CITY OF ALBUQUERQUE

February 9, 2024

**RE: Rio Grande Apartments
2211 Rio Grande Blvd. NW
Grading and Drainage Plans
Engineer's Stamp Date: 01/22/24
Hydrology File: H12D024**

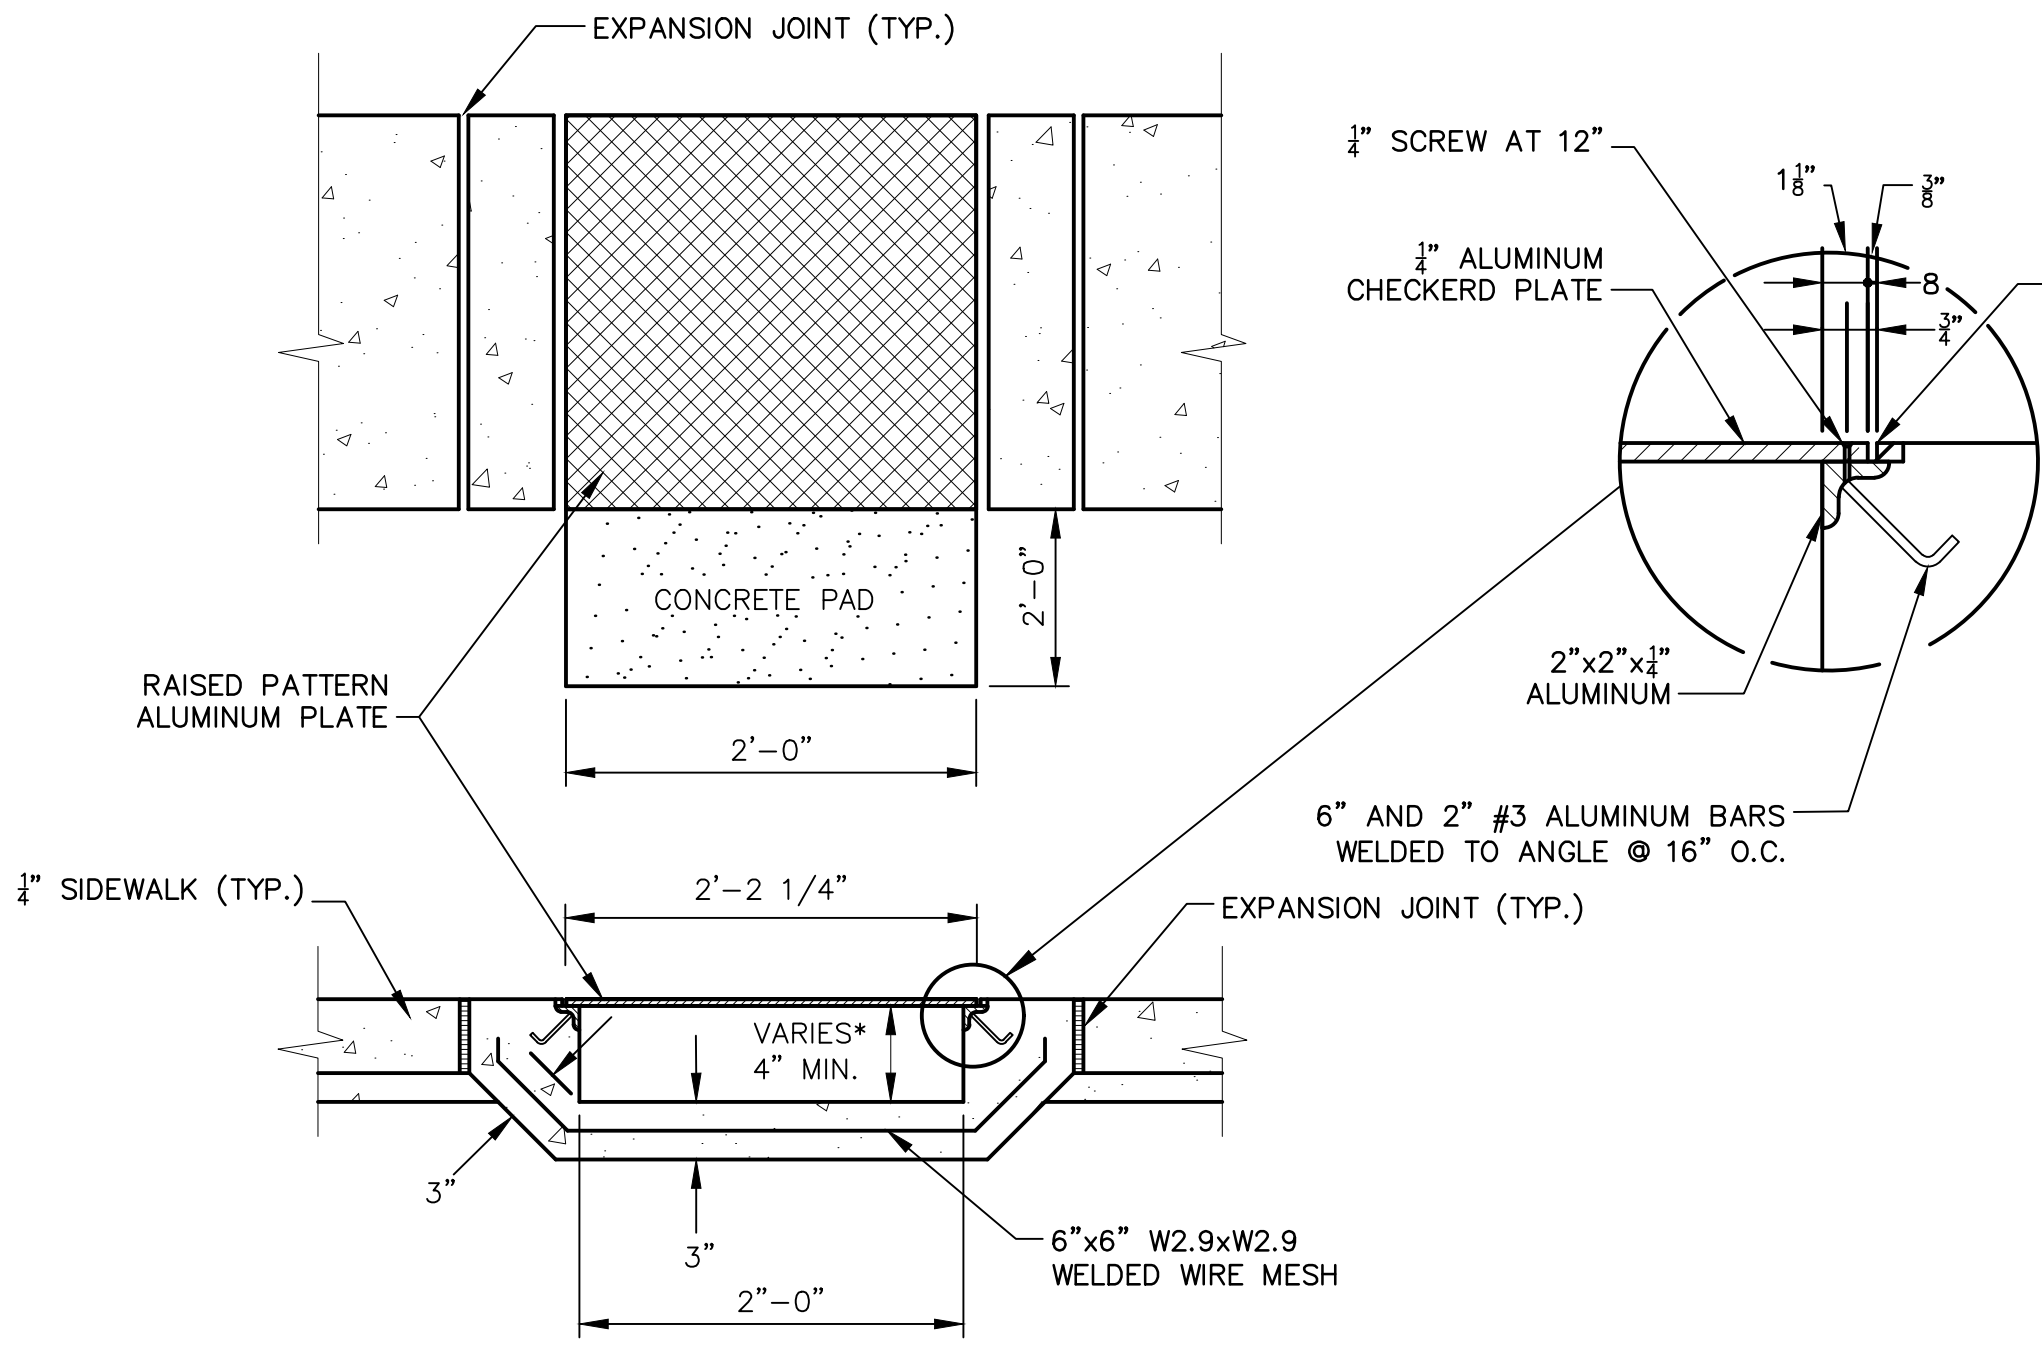
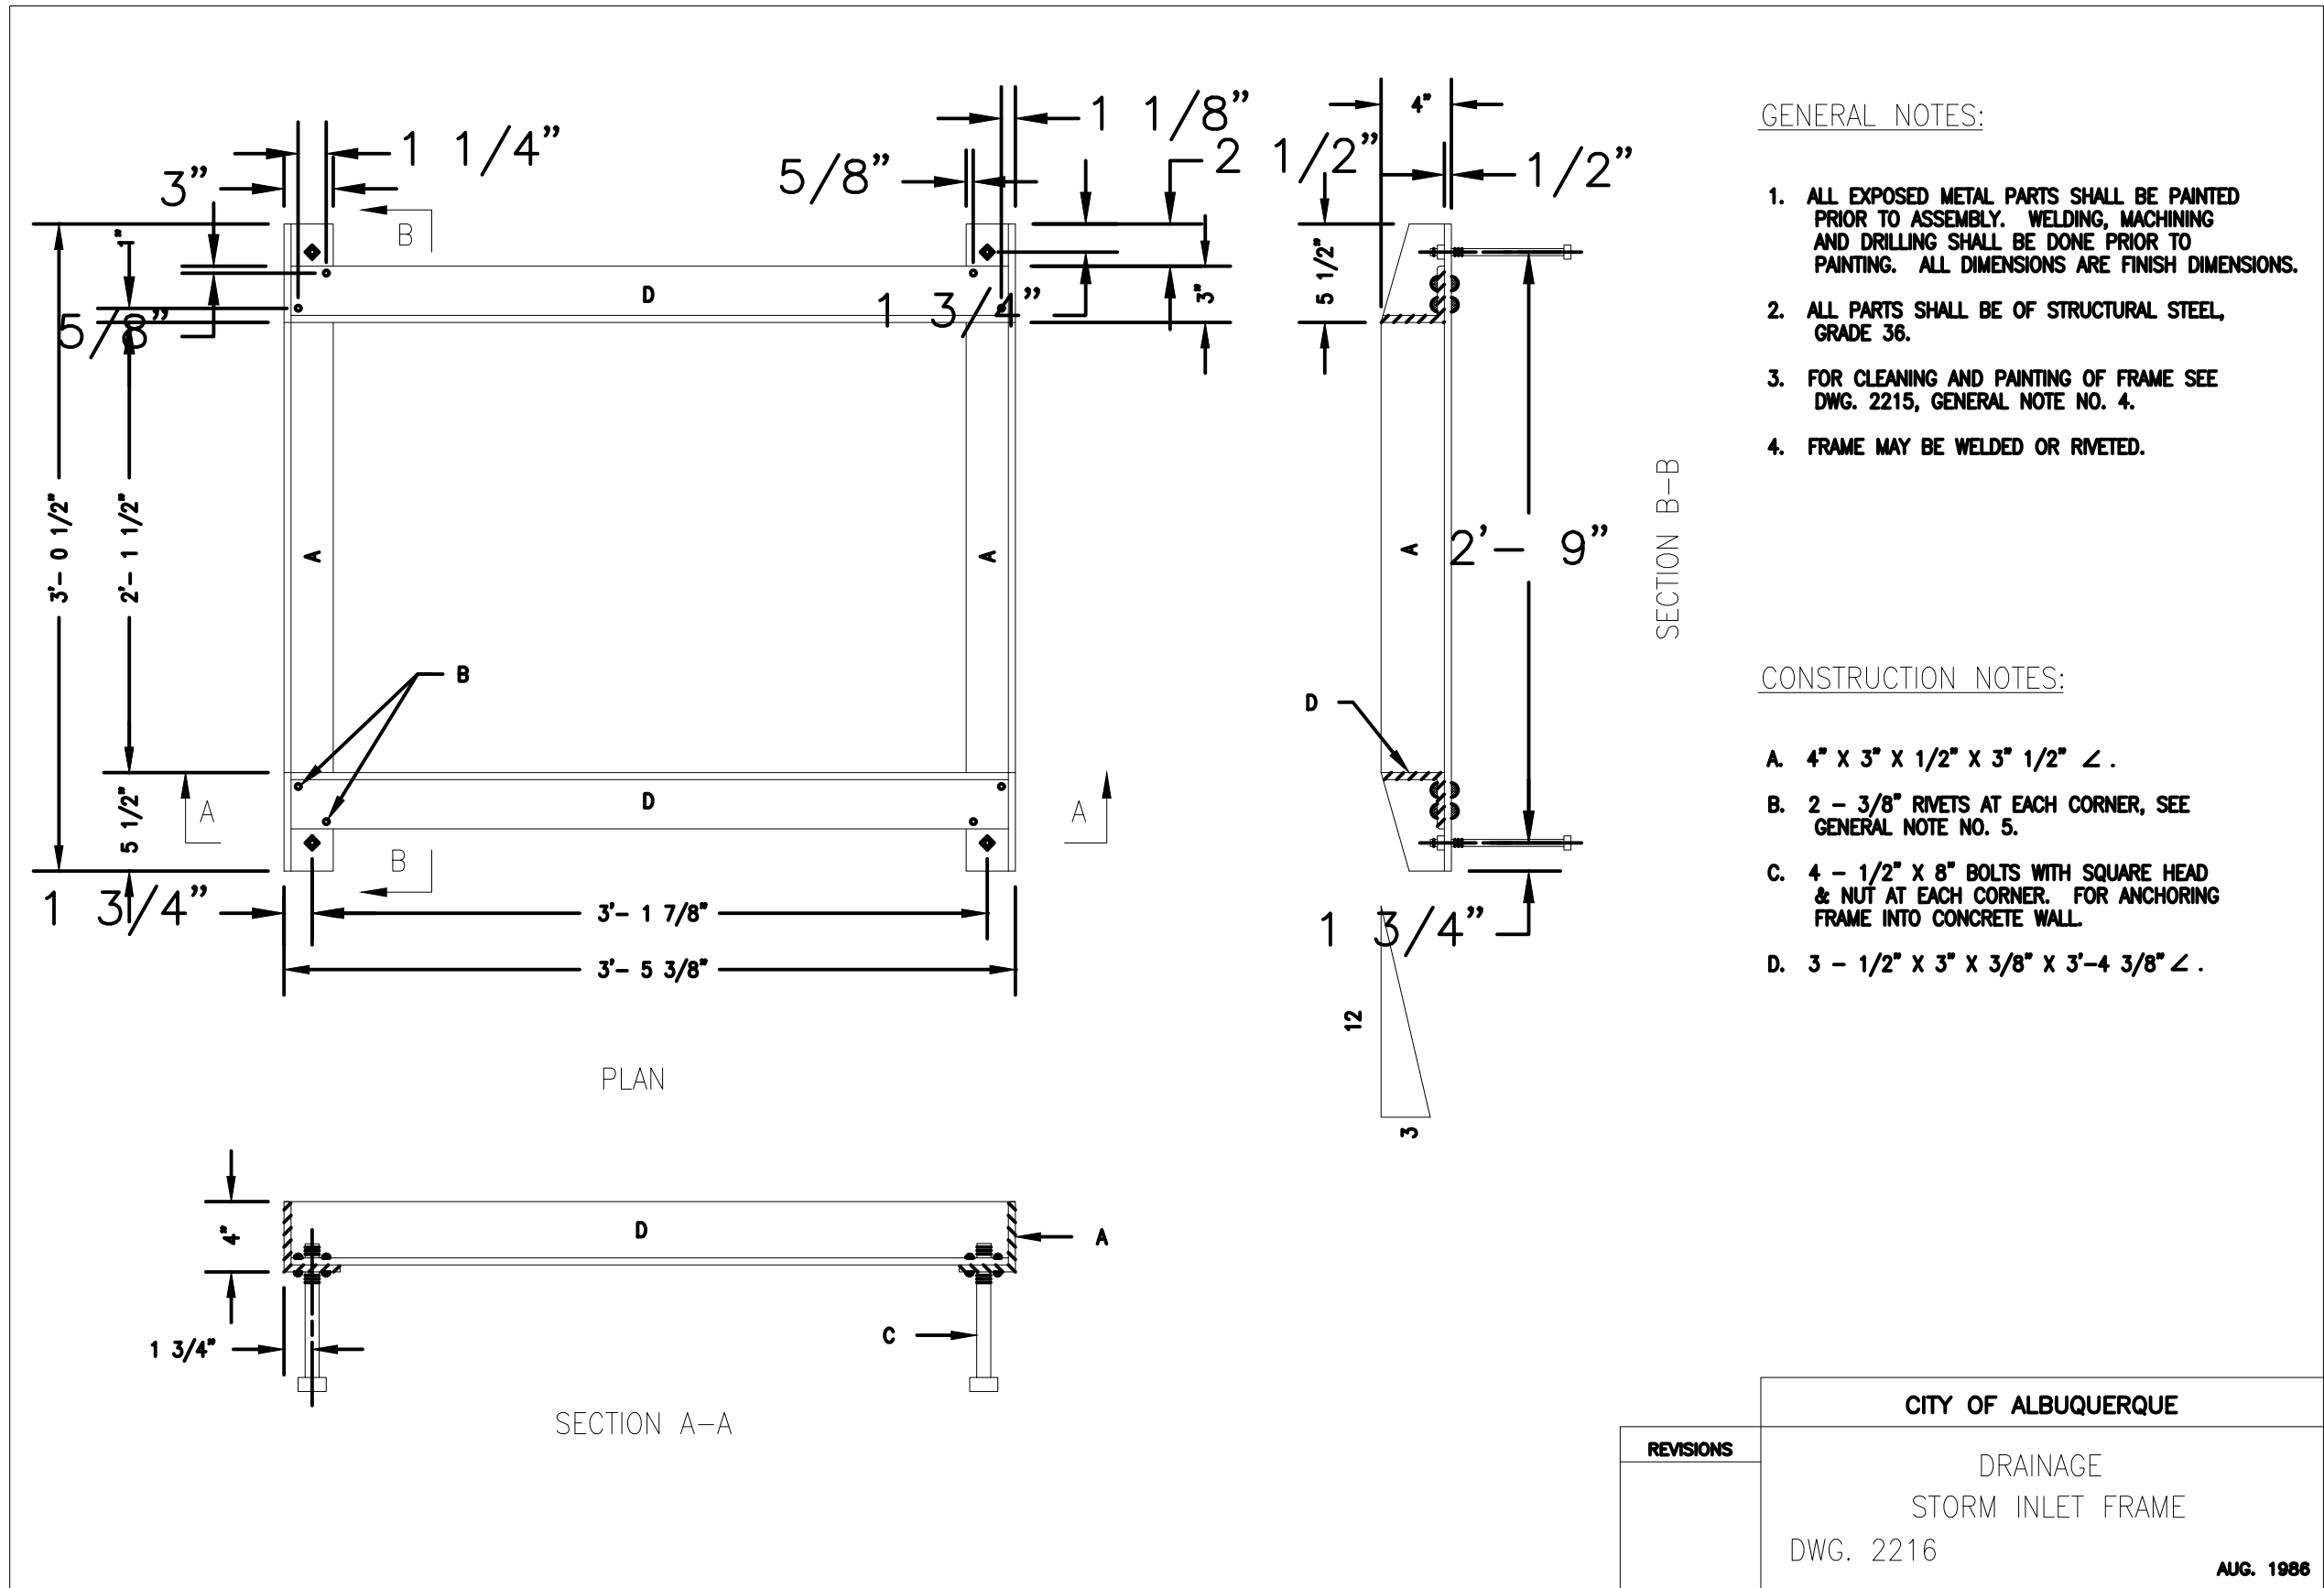
SHEET C-501

14. In the cross section, please showing property/ROW lines and add a note stating that the contractor shall waterproof the proposed retaining wall below the 100-yr 10 day water surface elevation of XXX per City standards. In accordance with DPM, grading and wall construction near the property line may not endanger adjacent property or constrain its use. Please make sure that the footer for the wall stays within the project's property. Also move this onto the Grading Plan per Comment #10.

15. The remainder of the details on this sheet or either just standard City details, which don't need to be shown. Just call them out on the Grading Plan as per COA Standard Drawing XXXX.
